# DRAINAGE LETTER

## 7280 N. NEVADA LANE

PCD File: [PPR2411](#)

SUBJECT: Drainage Letter, 7280 N. Nevada Lane

7280 NEVADA LANE
SAND CREEK DRAINAGE MAP
1"=200'

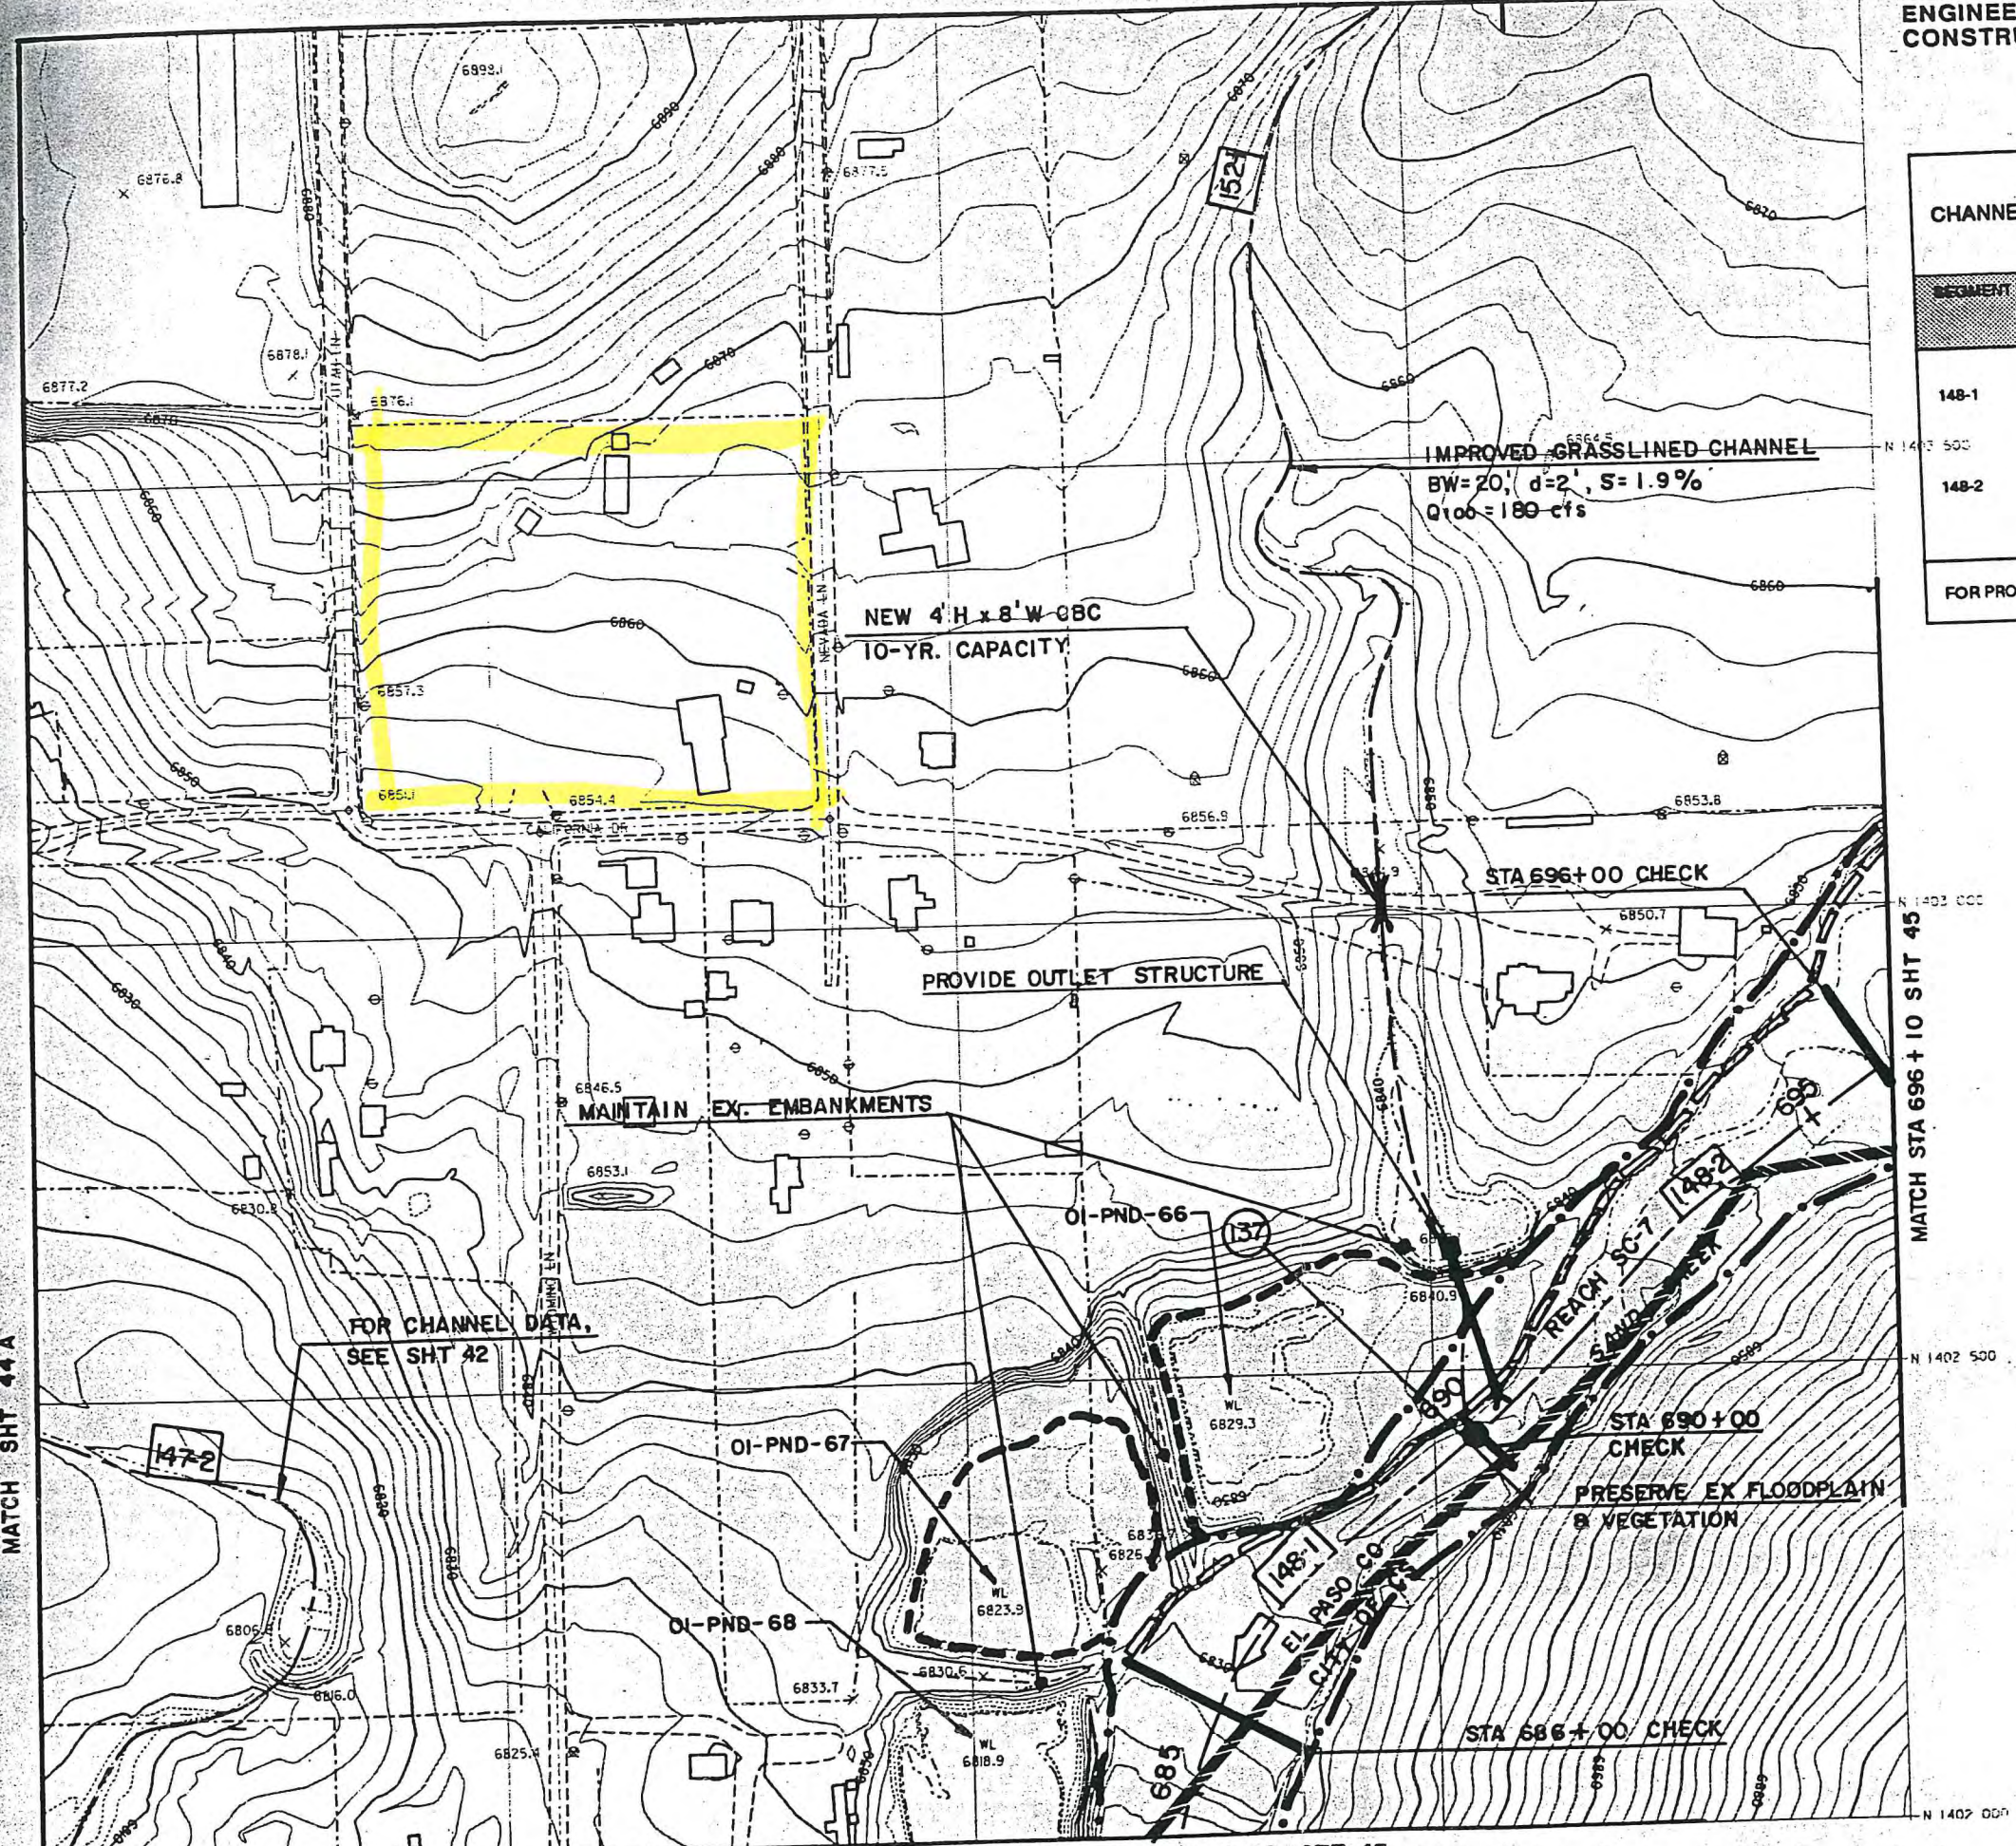
Please provide excerpt of this study. Please highlight all relevant information to the subject project.

DRAWN BY: D.E. WATTS
 DATE: 11-2-23
 DWG. NO.: 23-5924-04

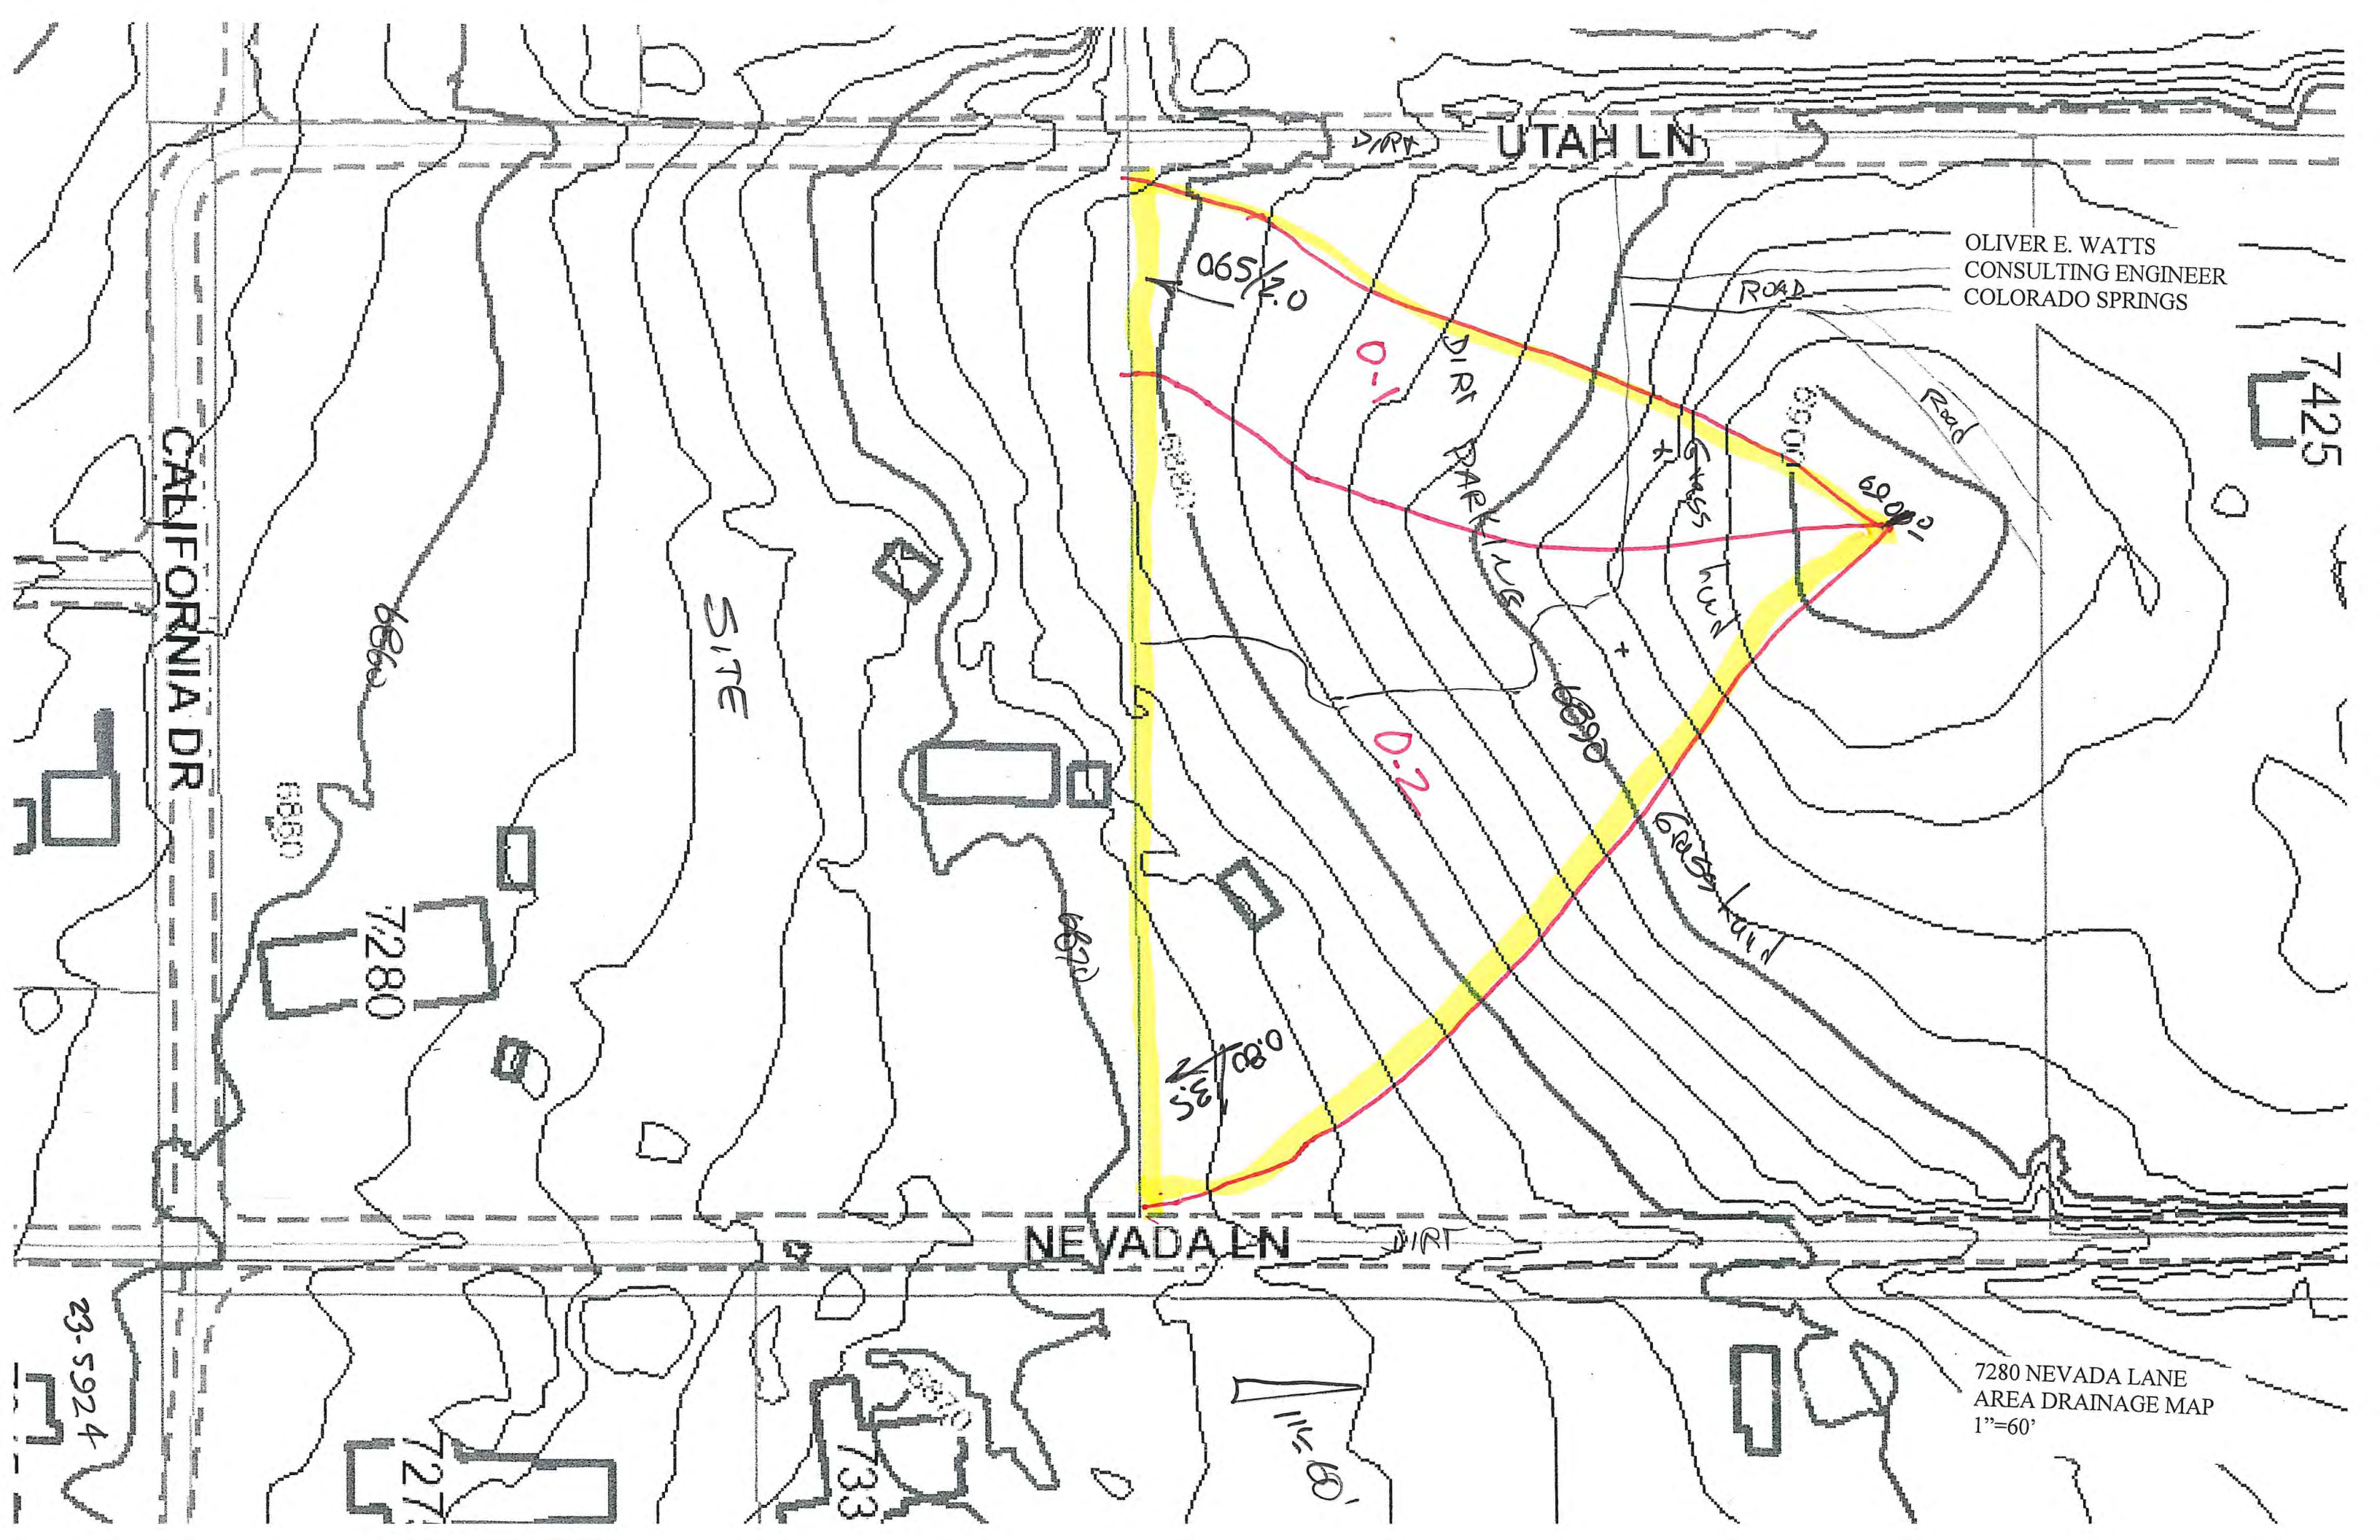
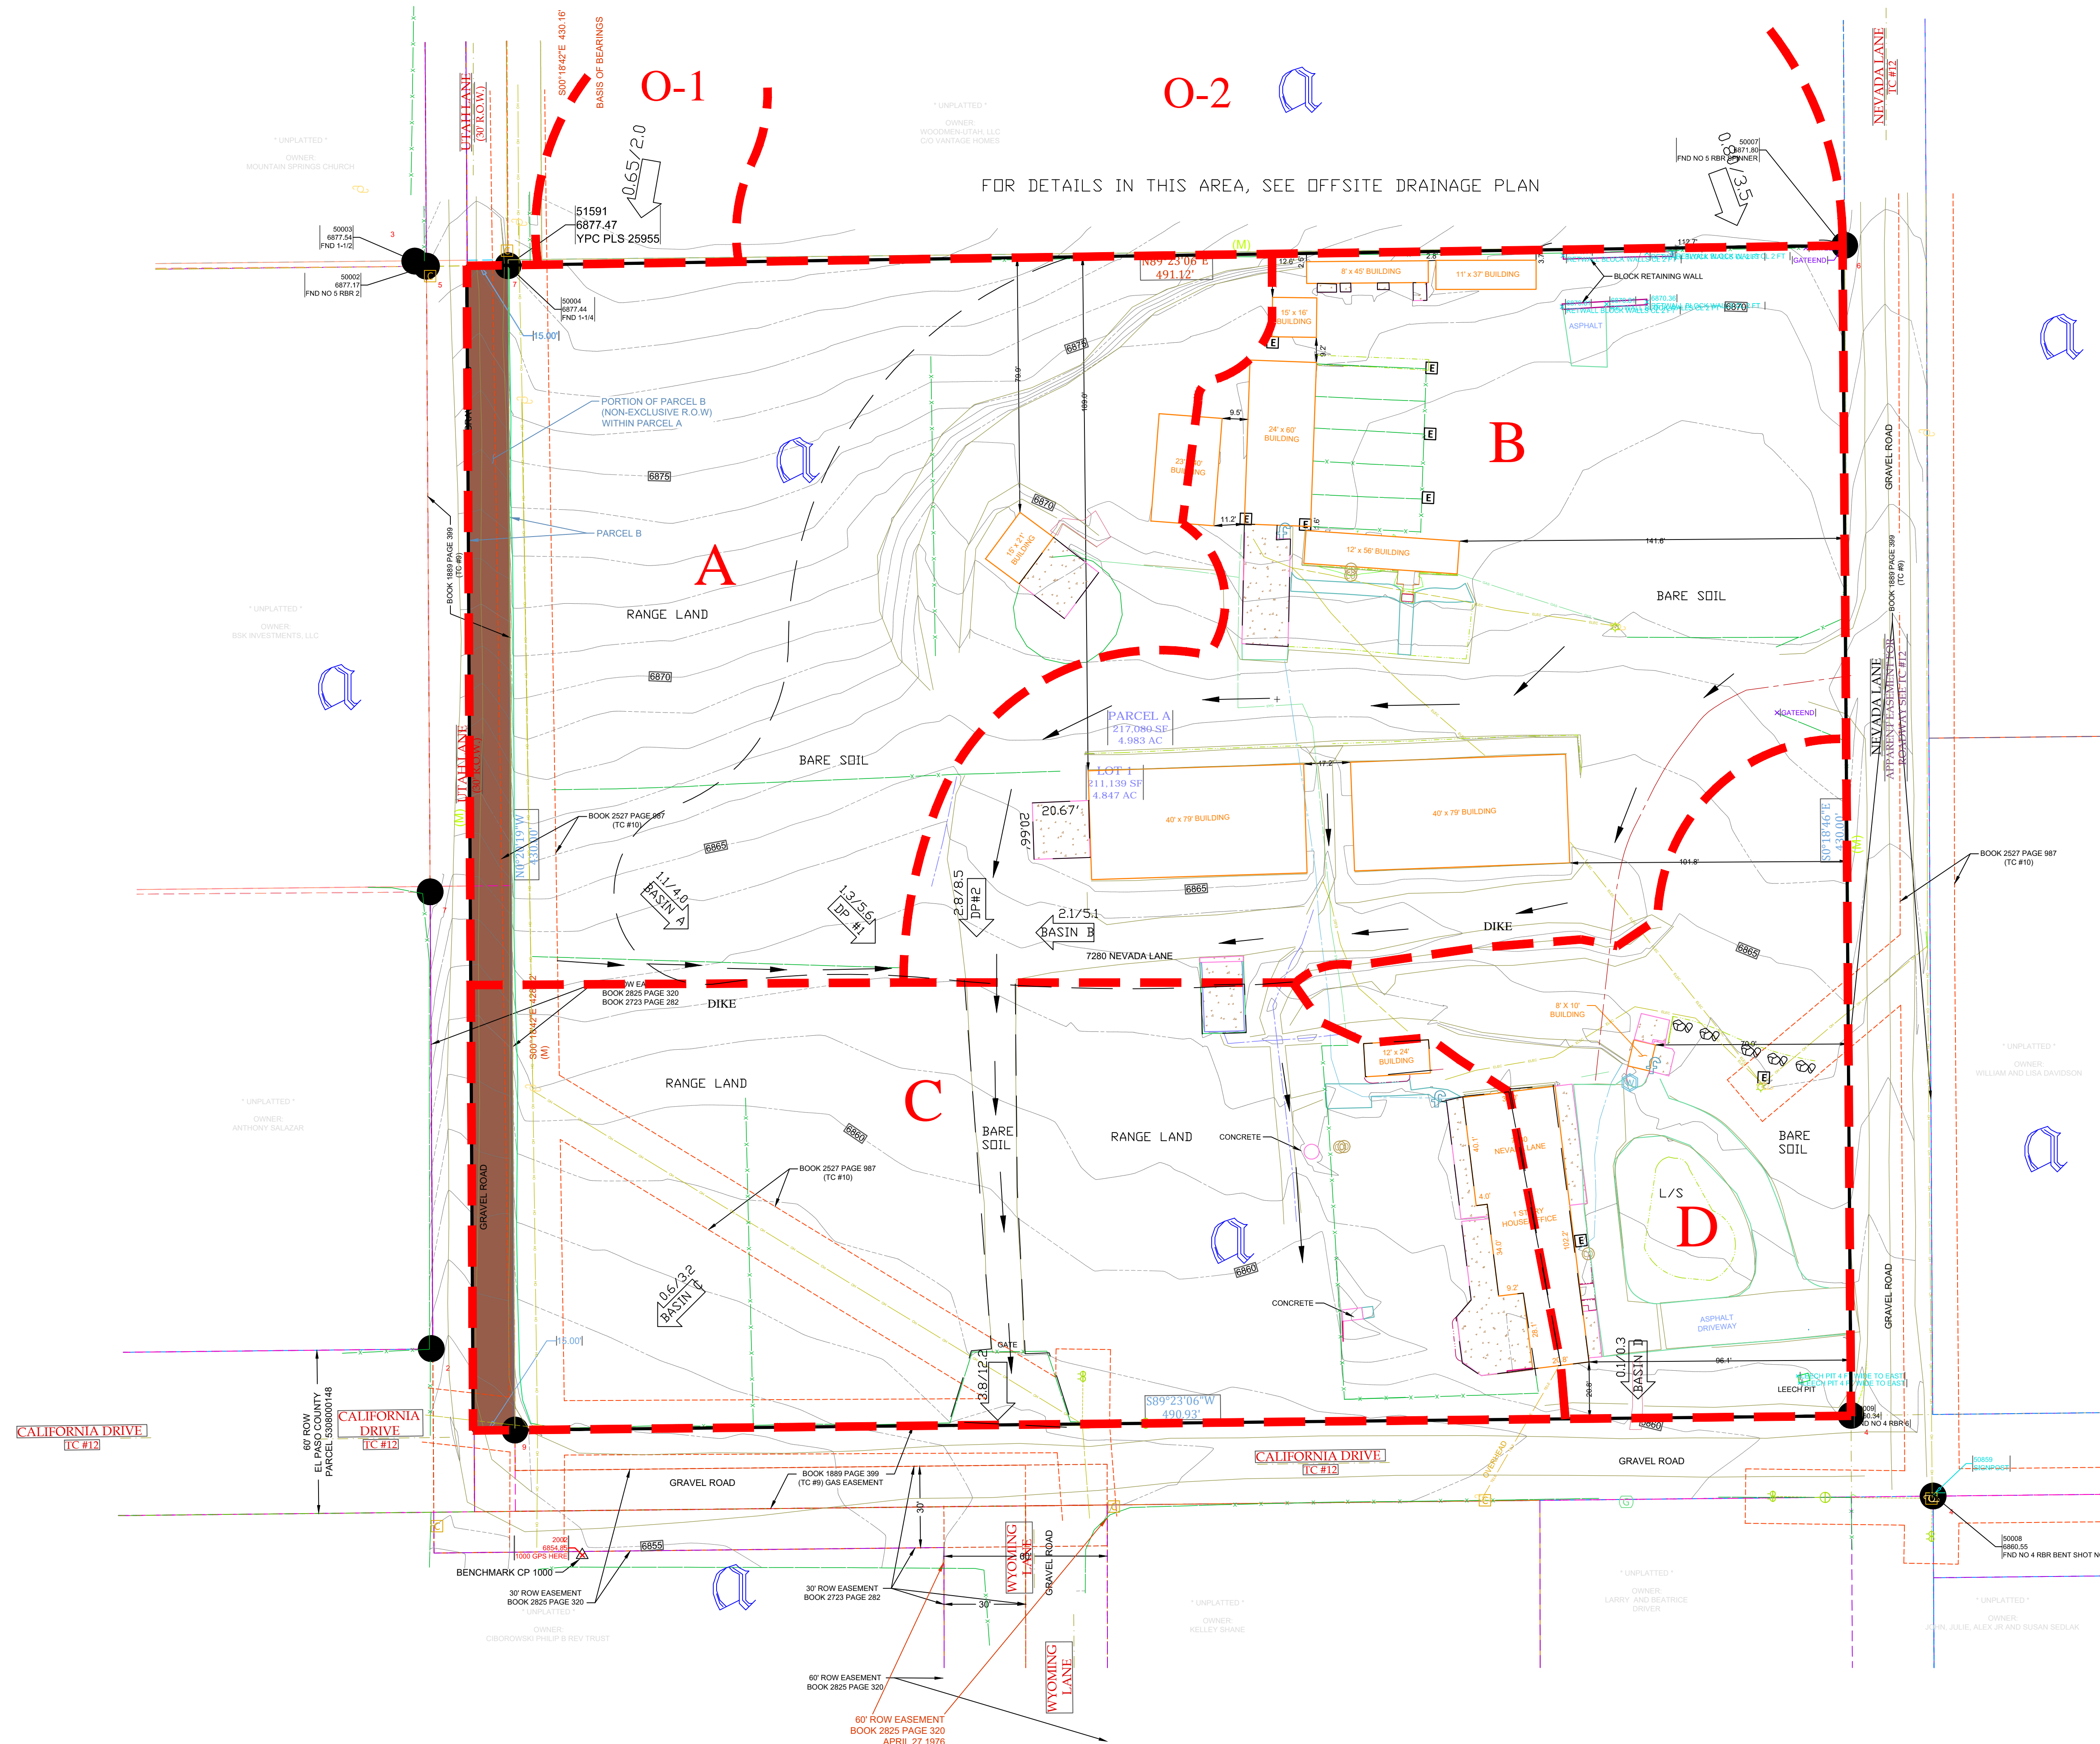
An existing drainage map is required.

From recent aerial imagery, the northwest corner of Basins B appears to be gravel, not bare soil. Please review and revise this map and calculations above where appropriate.

Please display and label the curb and gutter.

Please discuss proposed storm sewer in the text.

It appears that there is no proposed storm on the proposed drainage map. Please verify.

Please show ROW.

All proposed drainage basins, and design points need to be discussed in the text.

Please show all design points on the maps.

Is this concentrated flows? If so please address how erosion can be prevented at the downstream.

How erosion can be prevented at the downstream?
